From: Russell and Mari [REDACTED]
Sent: 11 December 2013 20:59
To: Planning.Responses; Charlotte Burrows; Planning
Subject: FW: Further Information Required on Your Ref: PP-02287986 Our Ref: WA/55/13/
Attachments: WA_55_13_140930_159643.pdf; GF Plan Model (1).pdf

From: planning.responses@arun.gov.uk [<mailto:planning.responses@arun.gov.uk>]
Sent: 27 November 2013 14:34
To: [REDACTED]
Subject: Further Information Required on Your Ref: PP-02287986 Our Ref: WA/55/13/

PROPOSED GROUND FLOOR PLAN

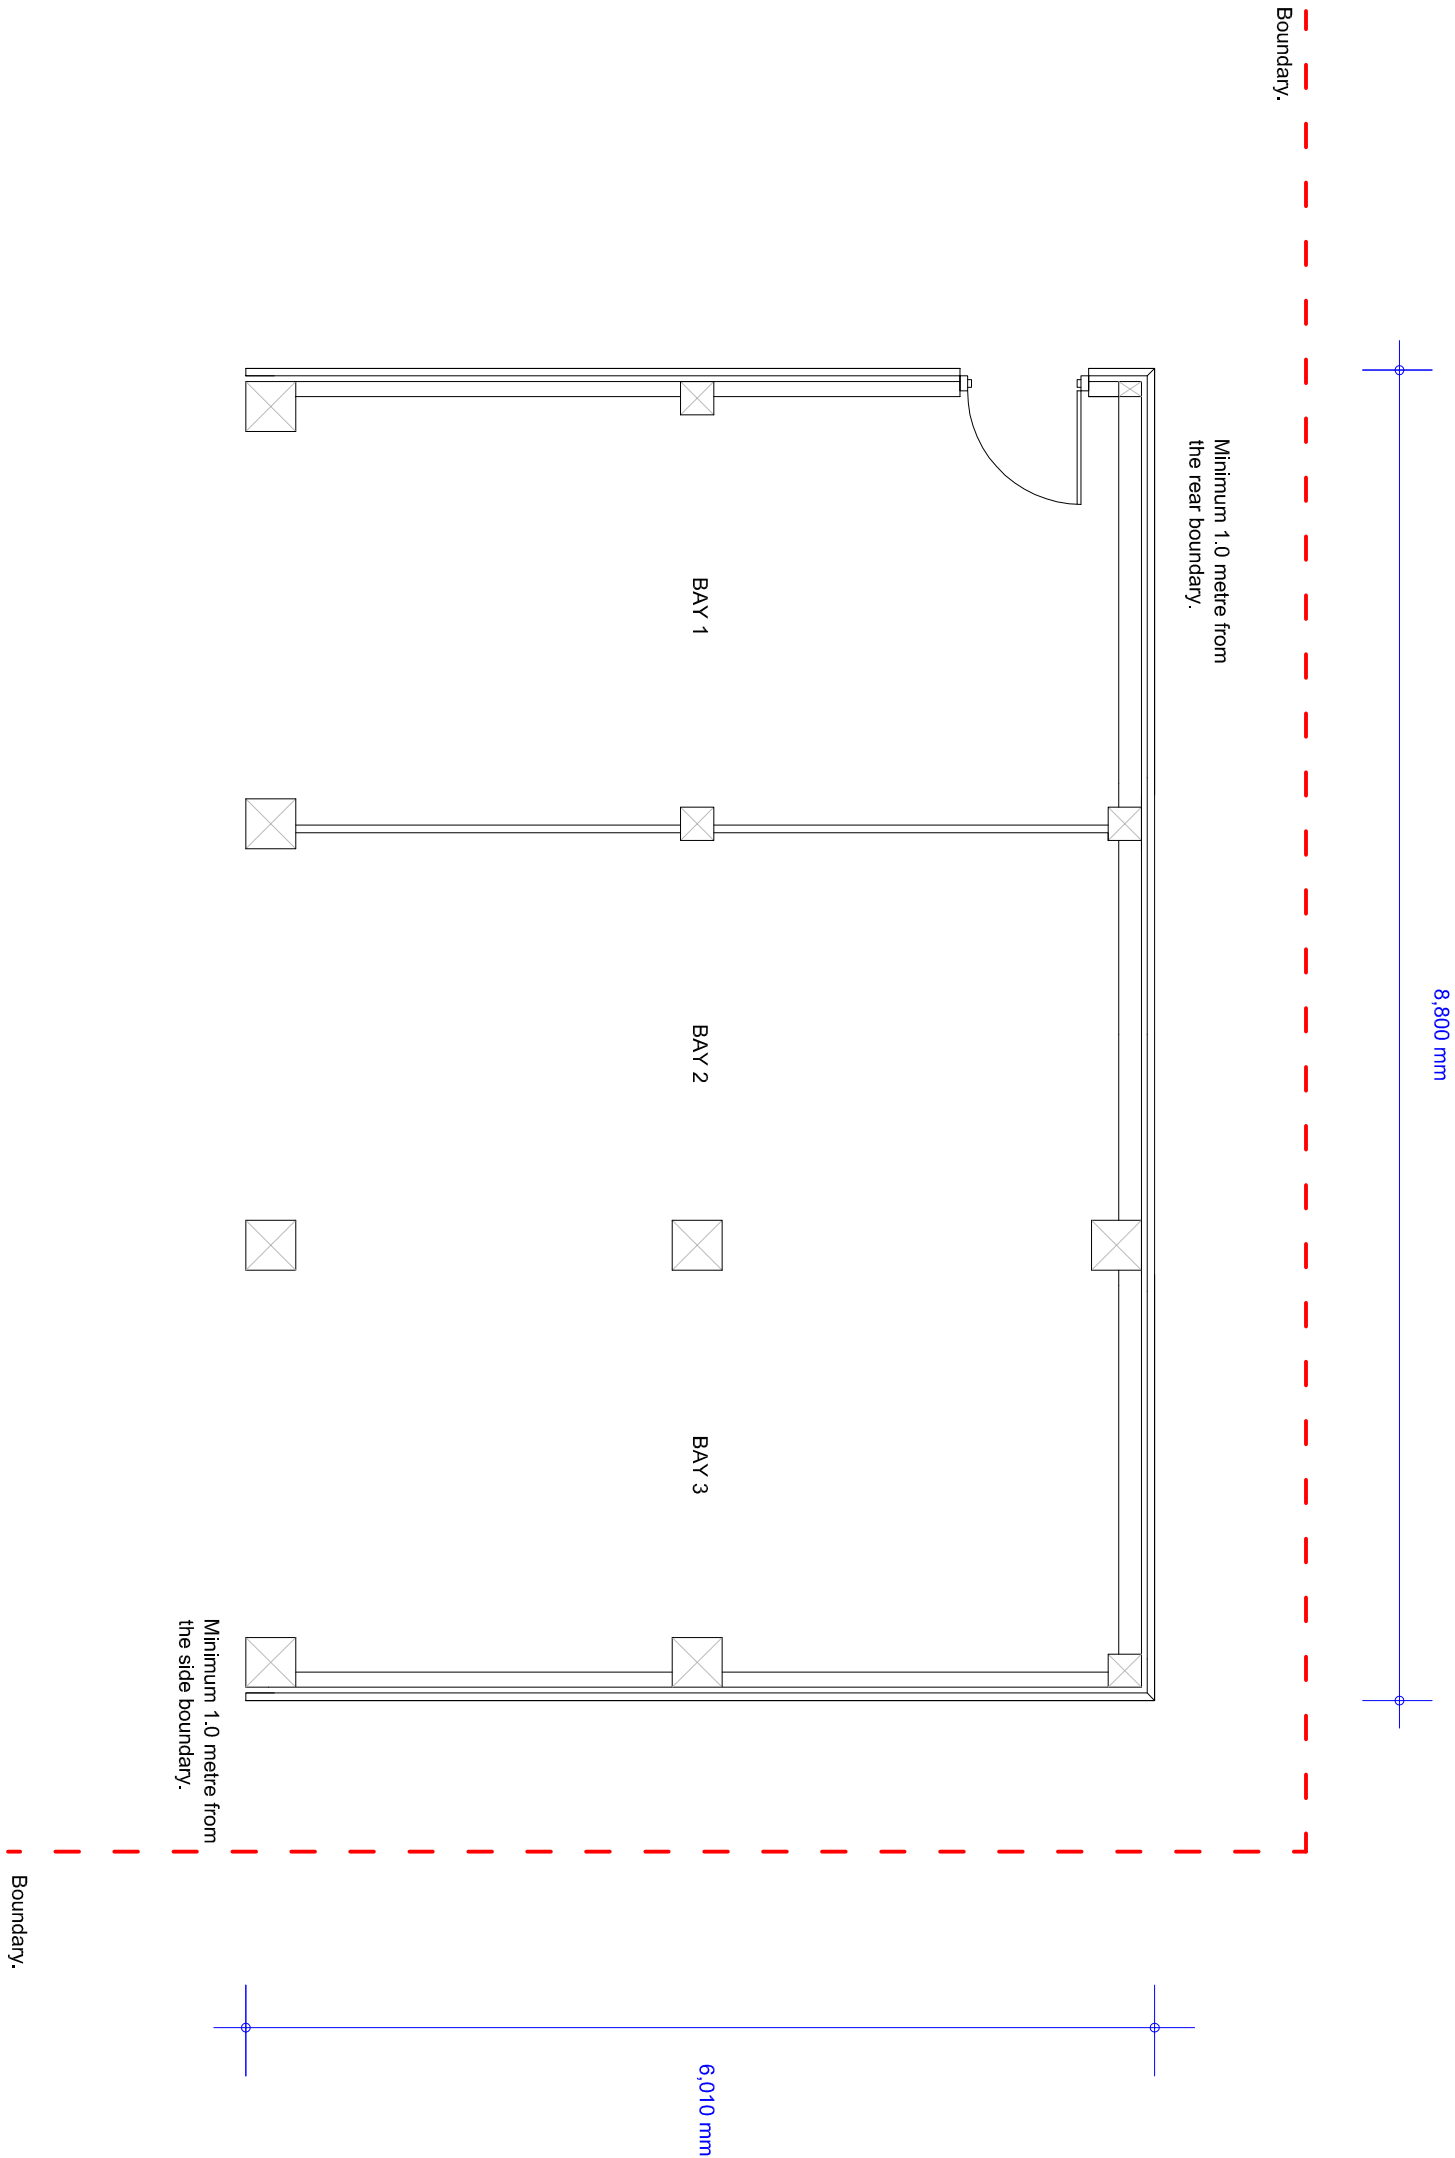
Please find revised floor plan attached showing doorway as requested.

On the comment regarding the correctly annotated floor plans – I would need to see what you submitted before I could comment, however, I would just phone Charlotte Burrows and ask direct – it is probably something silly like a title block so could be done pretty quickly.
